equinor

Your reference: EN010109
13 January 2023

Planning Inspectorate reference: EN010109
Application by Equinor New Energy Limited (“the Applicant”) for a Development Consent Order for the
Sheringham Shoal and Dudgeon Offshore Wind Farm Extension Projects (“the Application”)
Notification of the Applicant’s intention to submit requests for changes

TITLE  
A1067 / OLD FAKENHAM ROAD  
DRAFT  
ACC33 ACCESS DESIGN

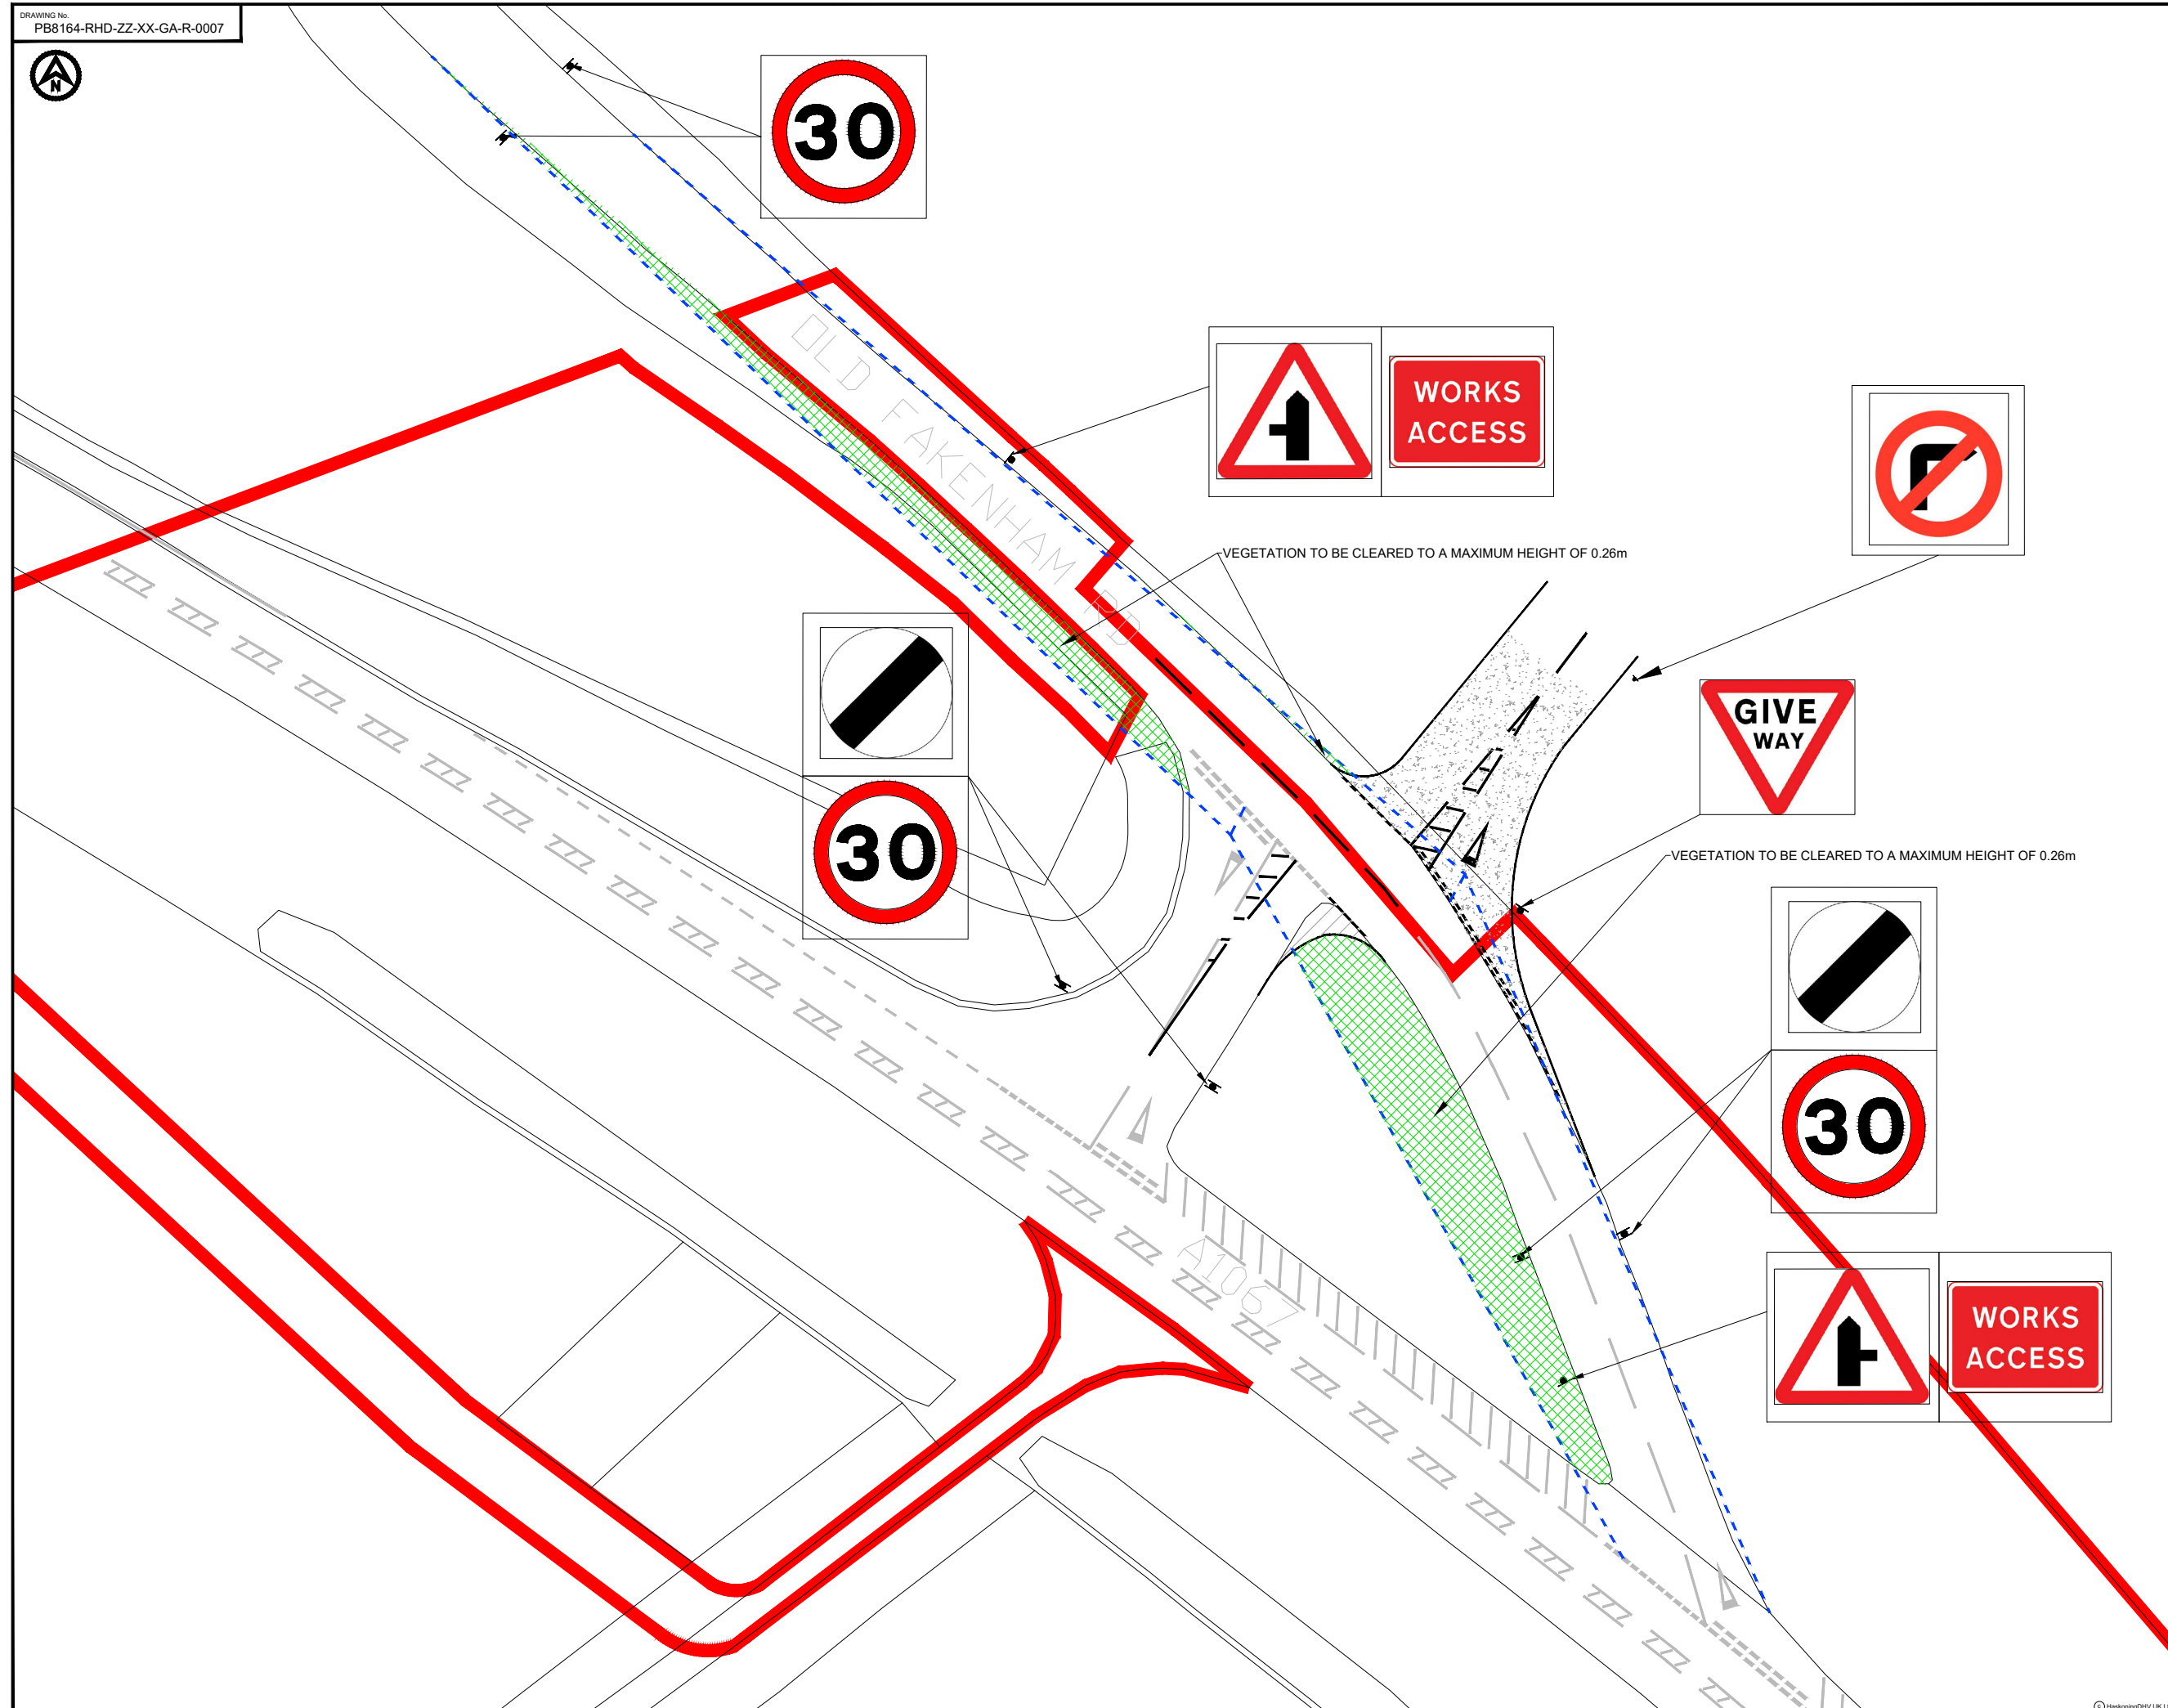
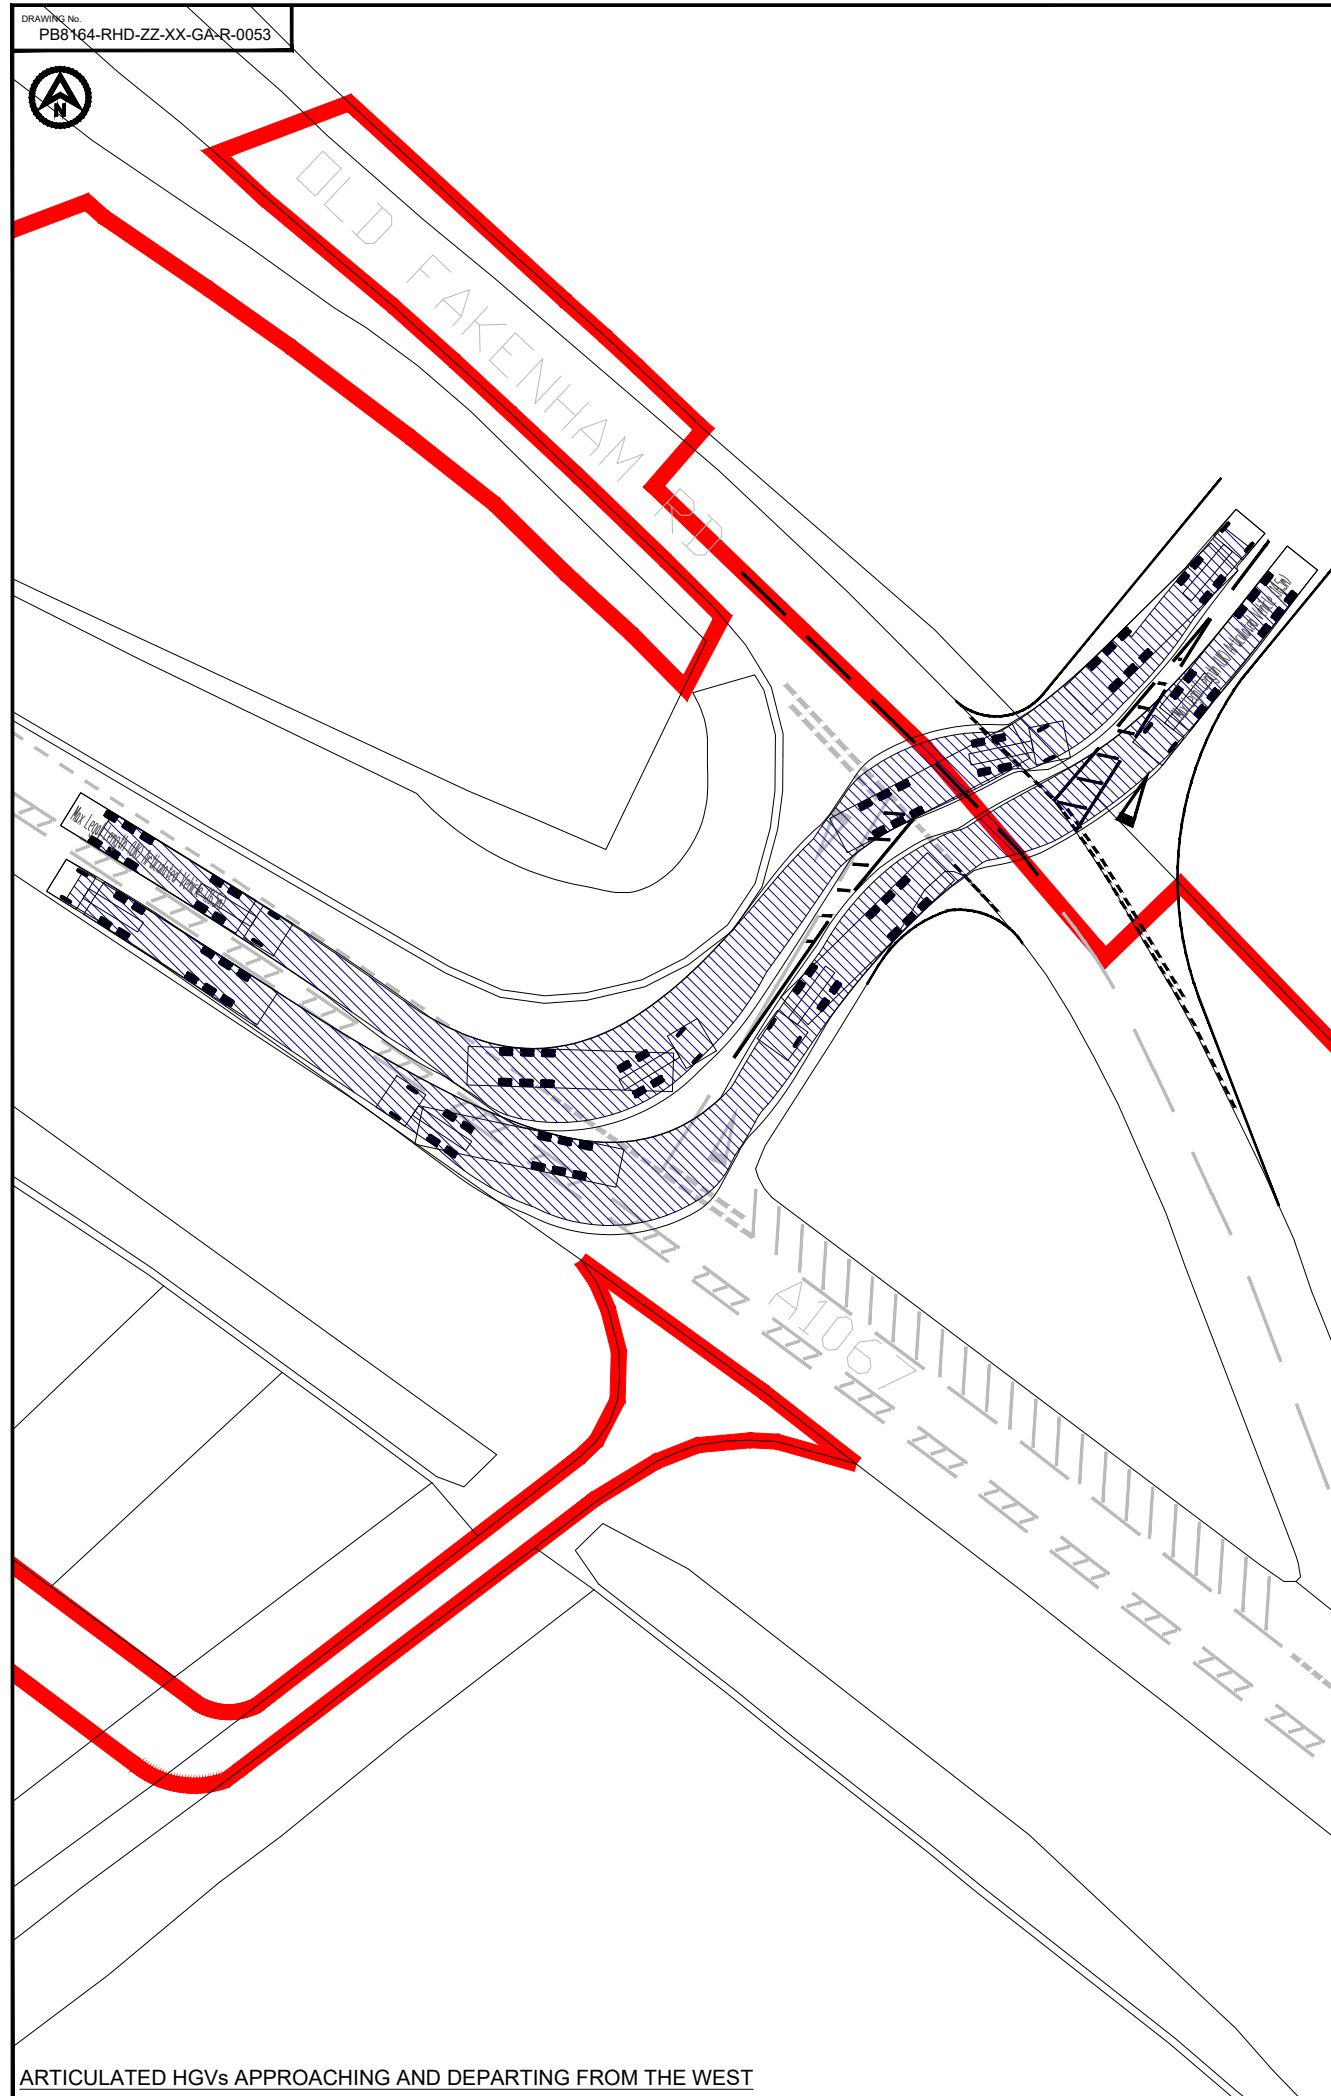
Hedgerow (H0103) is located to the south west of the proposed access (ACC33) to the main construction compound for SEP and DEP at the junction of the A1067 and Old Fakenham Road (the location of access ACC33 is detailed on Figure 24.6 of the Environmental Statement [APP-134]).

During stakeholder engagement with Norfolk County Council (NCC), NCC identified that they had concerns with the existing forward visibility of oncoming traffic at this junction (noting the proposed intensification of traffic associated with SEP and/or DEP traffic travelling to the proposed main compound). It was subsequently agreed that visibility would need to be improved at this location by either coppicing or removing the relevant hedgerow.

To allow this hedge (H0103) to be cleared (removed/or coppiced, as required) it will be necessary to amend the Tree Preservation Order and Hedgerow Plan [APP-017] and Schedule 16 of the draft DCO (AS-009) accordingly.
